CITY OF ALBUQUERQUE

December 6, 2021

Re: Copper Terrace Bldg A
12801 Copper Ave. NE
Traffic Circulation Layout
Architect's Stamp 11-16-2021 (K22-D062)

sheet no:  
 TCL1.0

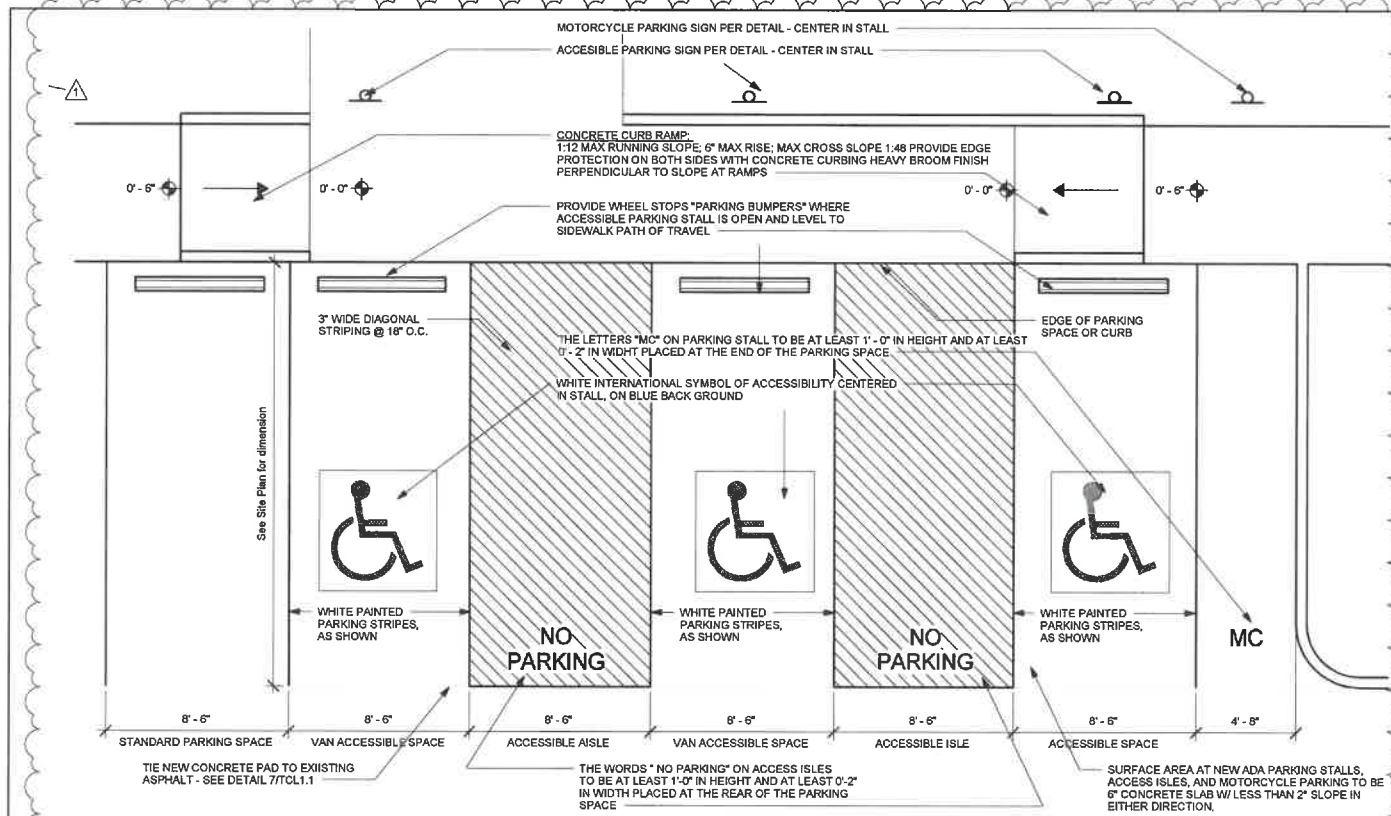
1. Sheet TCL1.0:

- Keyed Note 8: States sidewalk with curb. Please provide curb detail.
- Curbing is shown on this sheet so details will be needed.
- 2/TCL1.1:
 1. The details shows raised sidewalk but no detail is shown for this. Detail will be needed.
 2. Parking bumper shown but no details provided. Please provide.

TRAFFIC CONTROL LAYOUT 2  
**COPPER TERRACE APARTMENTS**  
**RECONSTRUCTED BUILDING A**  
12801 COPPER AVE NE  
ALBUQUERQUE, NM 87123  
sheet no: **TCL1**

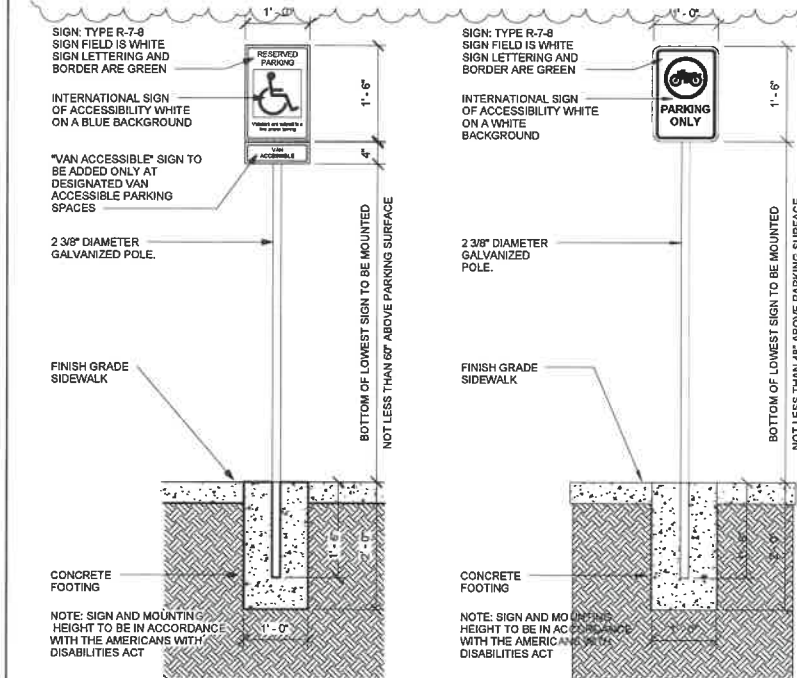
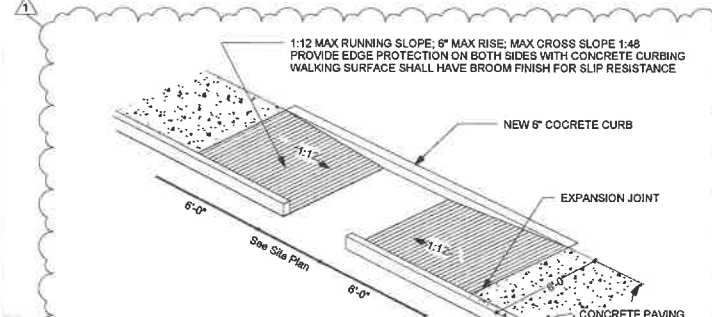
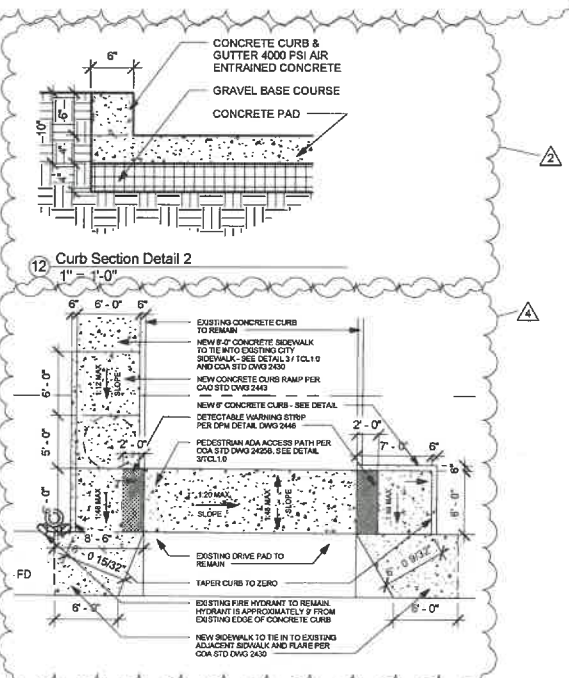
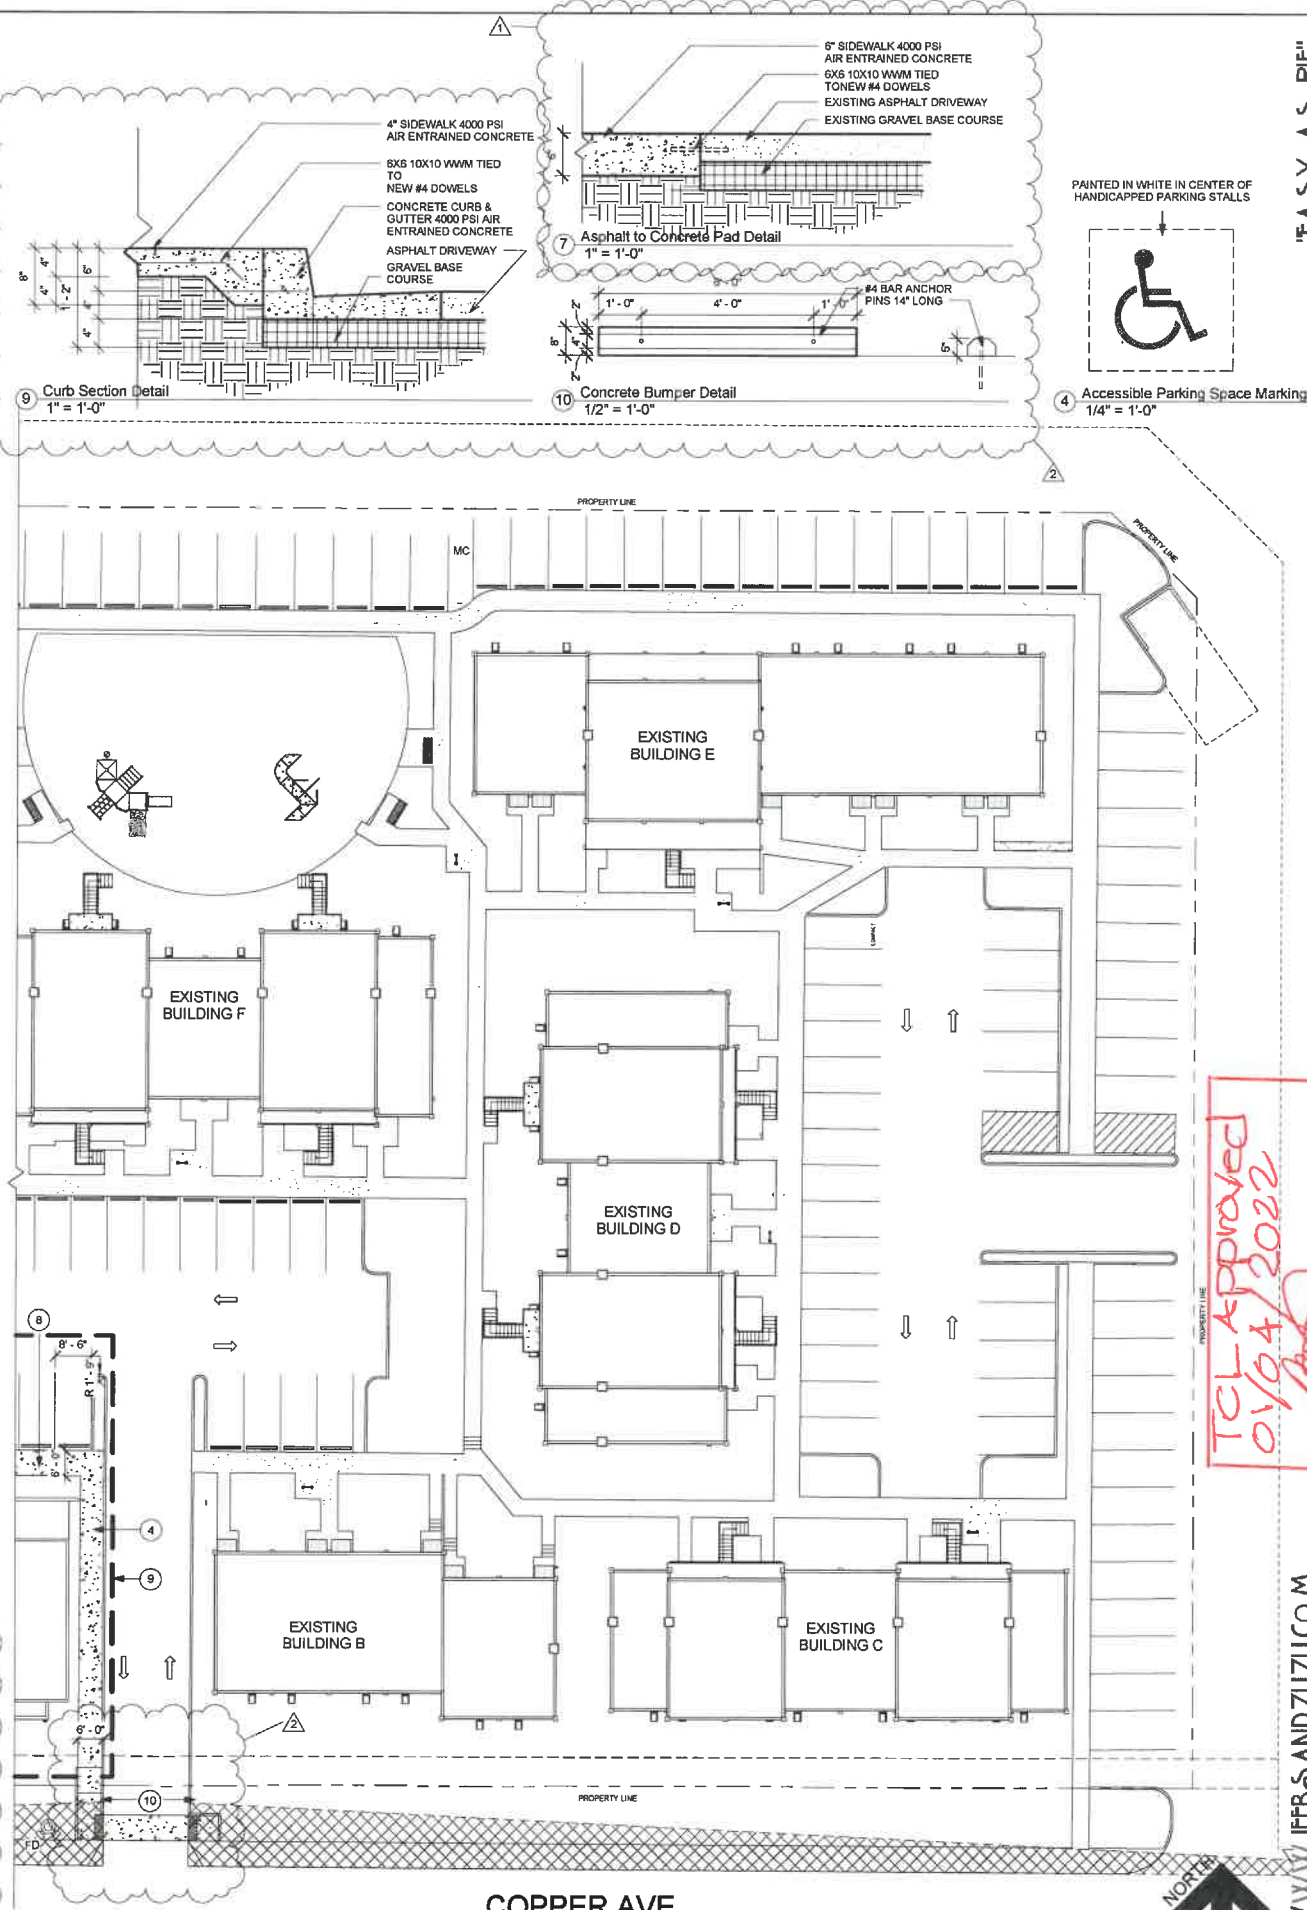
2. Sheet TCL1.1:

- Detail 8: This detail shows curbing but on sheet TCL1.0 there isn't curbing being shown. Please address.
- Detail 2: Parking bumpers shown on this sheet but not on sheet TCL1.0. this needs to be addressed.
